Our Ref: PEF/SD/28854
Your Ref: Y/21/18/DOC

26 April 2018

**Drainage
Land at Kings Close, Yapton**

PROJECT
Standard Detail
High Storage Soakaway

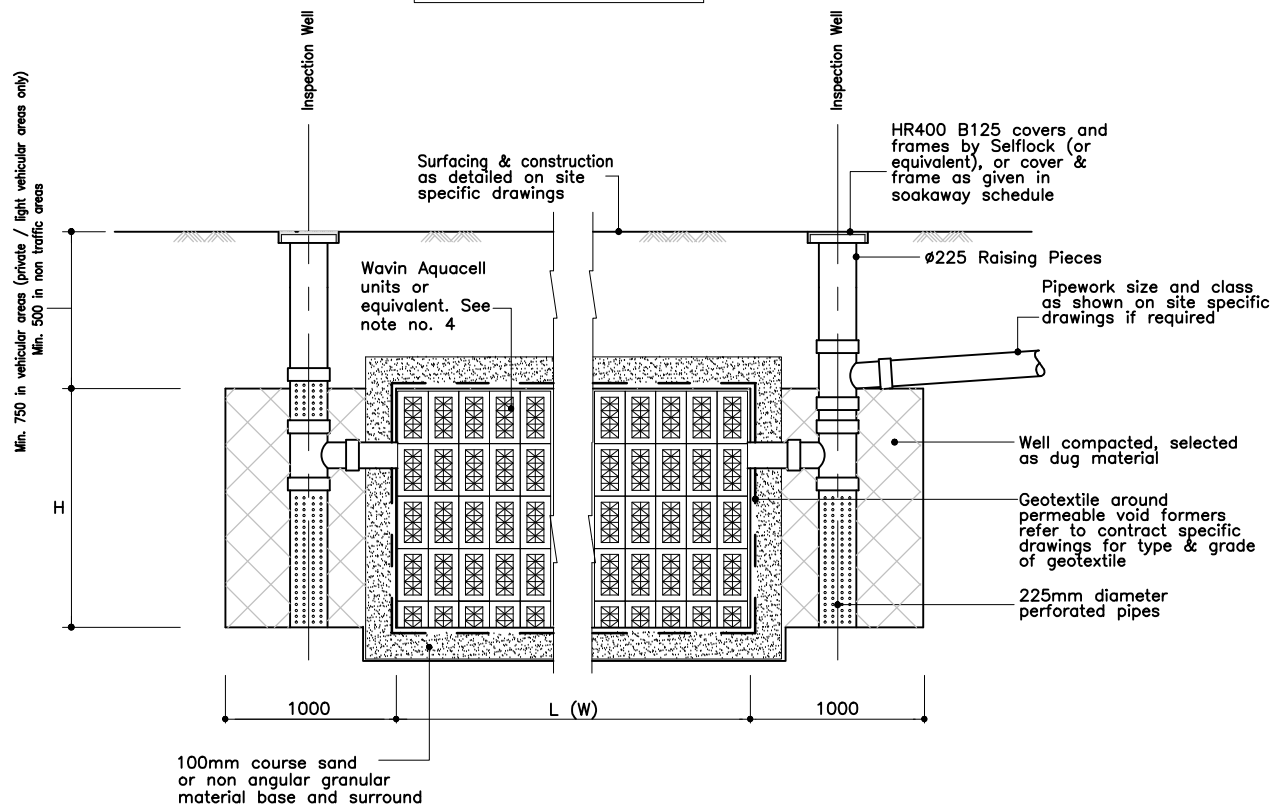
- 1) As shown on the soakaway schedule and standard detail, soakaways type SA 'A' have a total depth of 1.7m and an effective depth (H) of 1.2m. The calculated water depth of 1.13m is served by the 1.2m deep high storage soakaway.
- 2) As shown on the soakaway schedule and standard detail, soakaways type SA 'B' have a total depth of 1.7m and an effective depth (H) of 1.2m. The calculated water depth of 1.04m is served by the 1.2m deep high storage soakaway.
- 3) As shown on the soakaway schedule and standard detail, soakaways type SA 'C' have a total depth of 1.7m and an effective depth (H) of 1.2m. The calculated water depth of 1.12m is served by the 1.2m deep high storage soakaway.
- 4) Table 4.6 of Ciria Report 156 does indicate that a safety factor of 1.5 can be used for hydraulic design.
- 5) Drawings for soakaways, manholes and catchpits can be found herewith.
